**SABIC UK PETROCHEMICALS LIMITED AND SABIC PETROCHEMICALS BV (URN 20053908)**

**THE MORGAN OFFSHORE WIND PROJECT AND MORECAMBE OFFSHORE WINDFARM: TRANSMISSION ASSETS DEVELOPMENT CONSENT ORDER (EN020028)**

**DEADLINE 4**

**WRITTEN SUMMARY OF SABIC'S REPRESENTATIONS TO**  
**COMPULSORY ACQUISITION HEARING NO. 2**

**Figure 1.6: Permanent mitigation area south of Newton-with Scales**

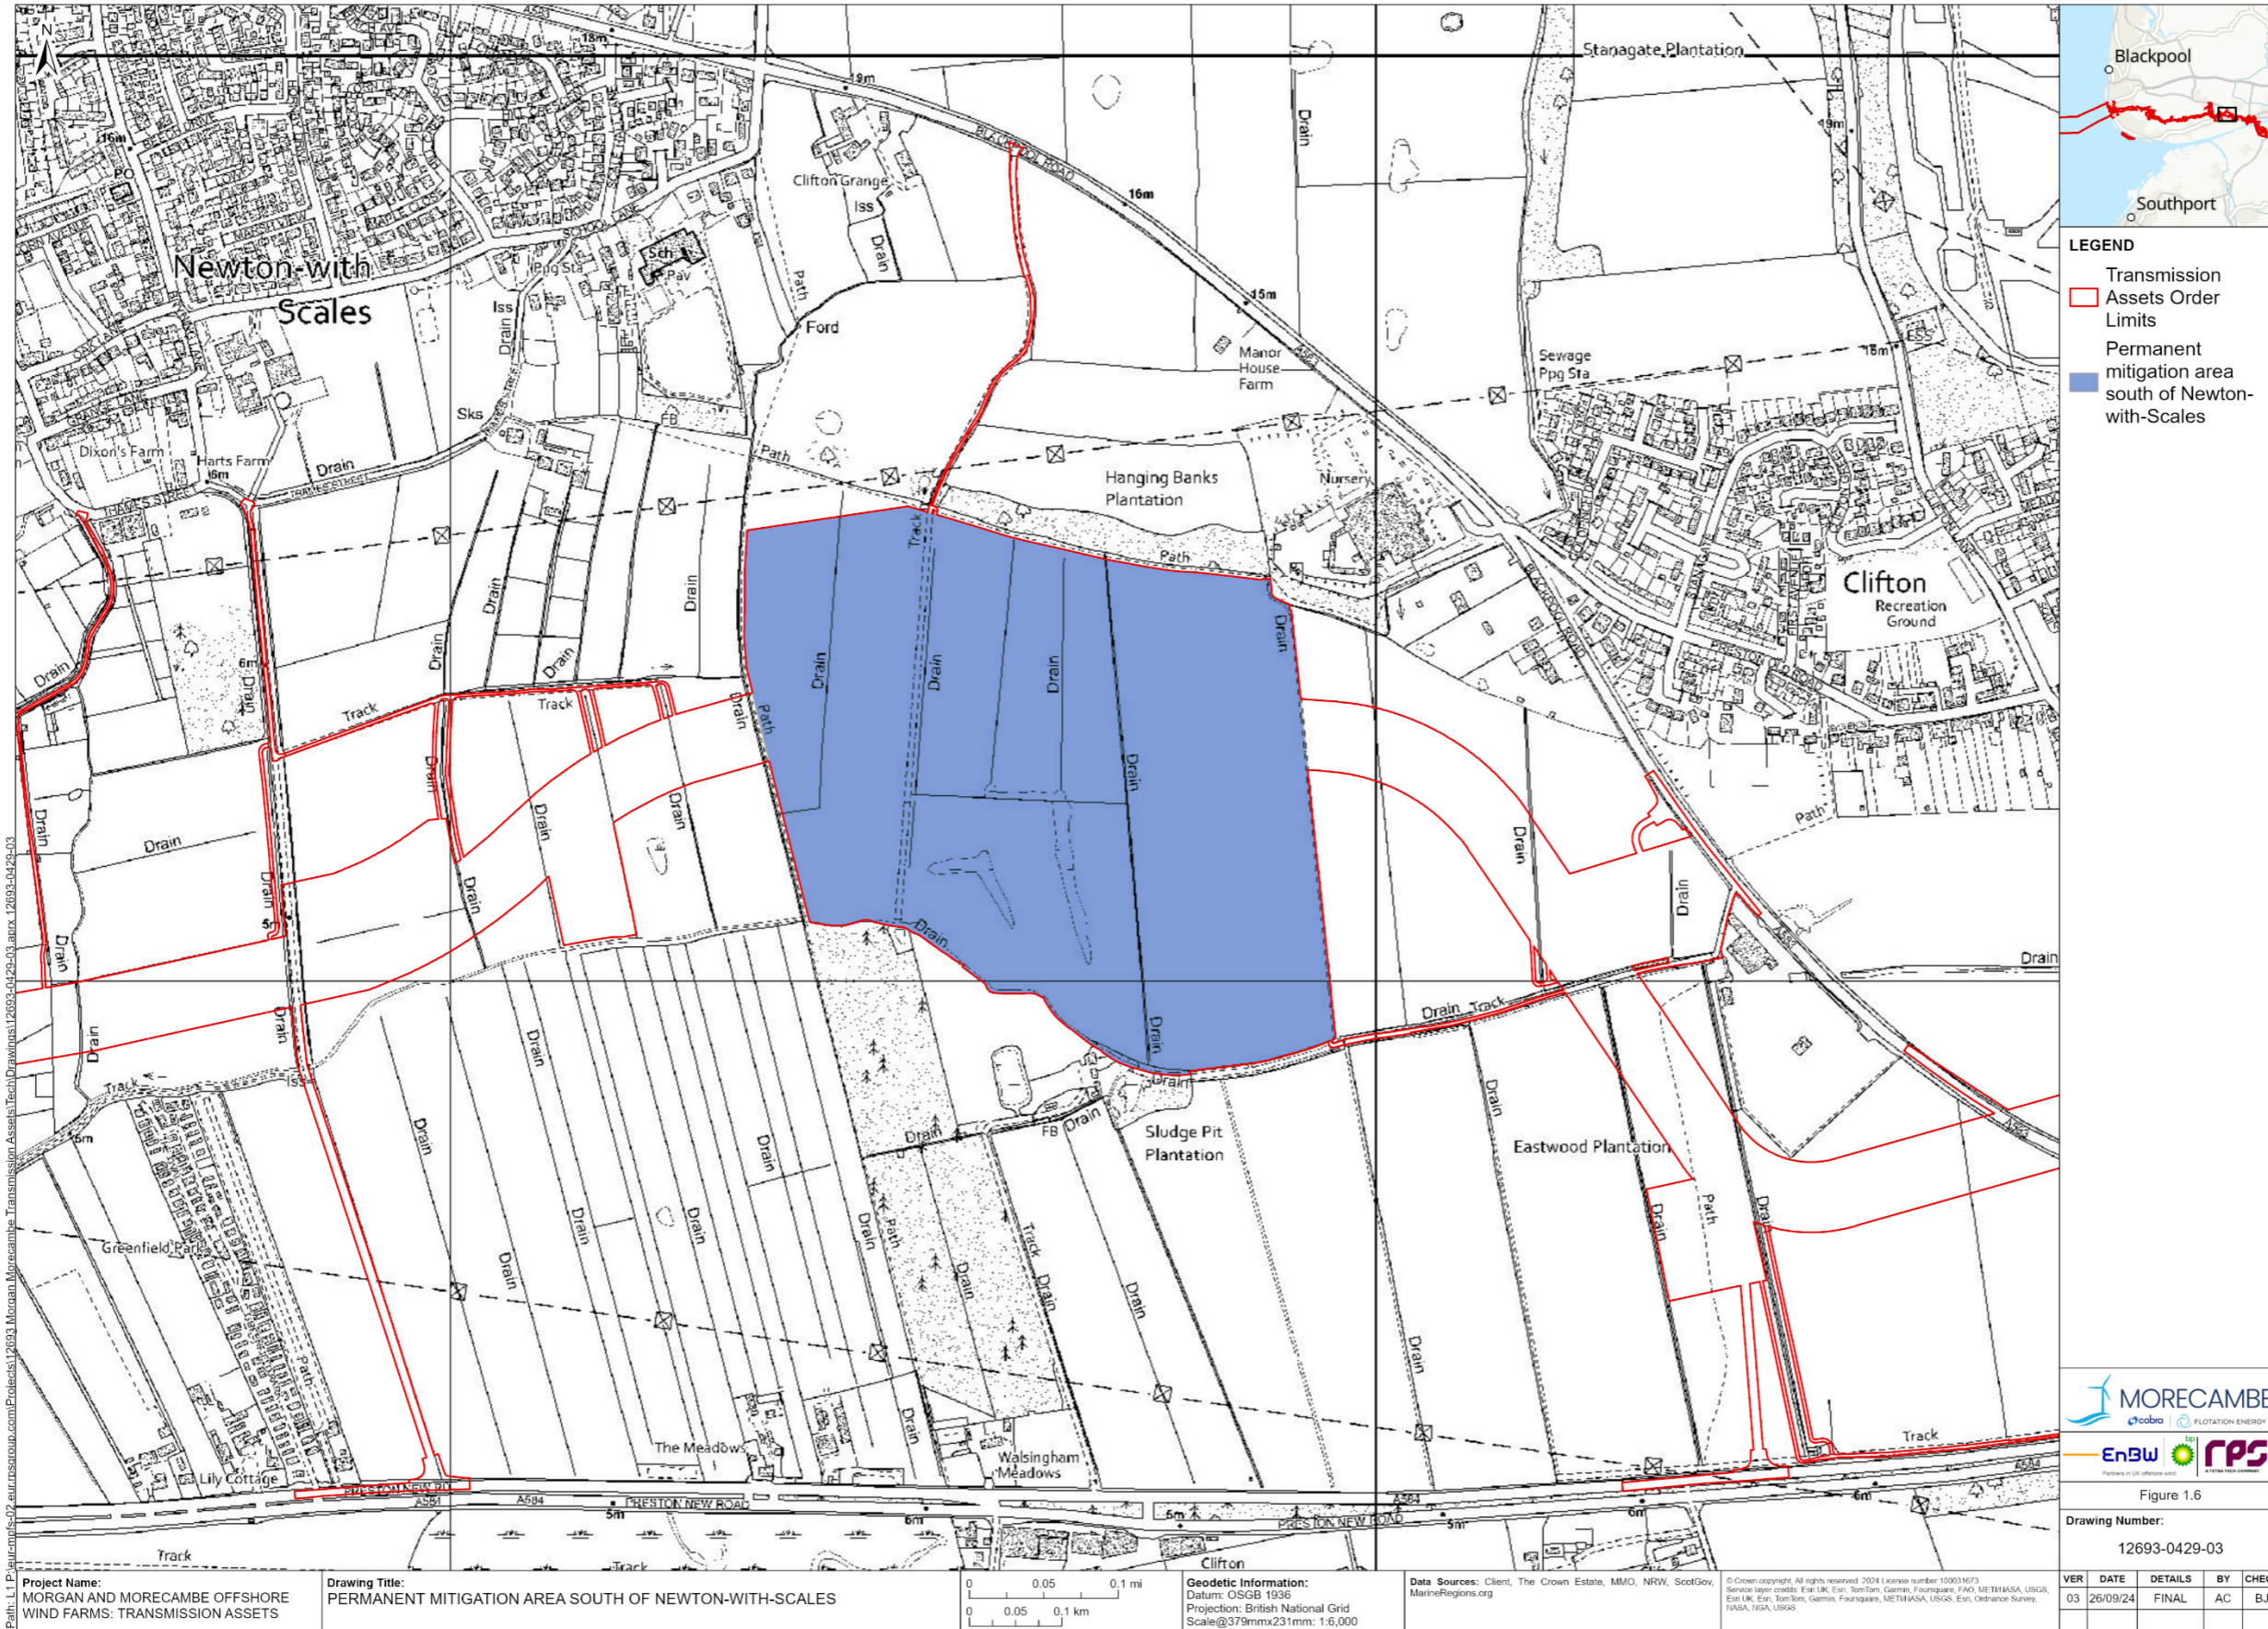
- 2.1 The EMP provides for wader scrapes and planting in the vicinity of SABIC's pipeline (the TPEP).
- 2.2 SABIC is concerned about where the proposed wader scrapes will be located in terms of loss of soil cover, erosion and land slip, which could affect the TPEP. A minimum 6 metre buffer needs to be provided between any part of the pipeline and any wader scrape.
- 2.3 It also considers that there should be an enforceable mechanism to ensure that the hedgerow planting required under this requirement, and requirements 6 and 7 accords with SABIC's standard restrictions on planting (which includes minimum distances for different species).

- 2.1.4 Additionally, the Applicant has chosen this location for the "permanent environmental mitigation works" (Work Nos. 49A and 49B), which include the creation of wader scrapes and planting which could also negatively affect the TPEP.

- 2.1.5 On this point, SABIC takes some comfort from the amendments to the Outline Ecological Management Plan submitted at Deadline 2 [REP2-018] which recognises the location of the TPEP and the need for stand-off distances for the wader scrapes. However, SABIC considers that amendments will still be needed to the protective provisions to deal with their concerns.
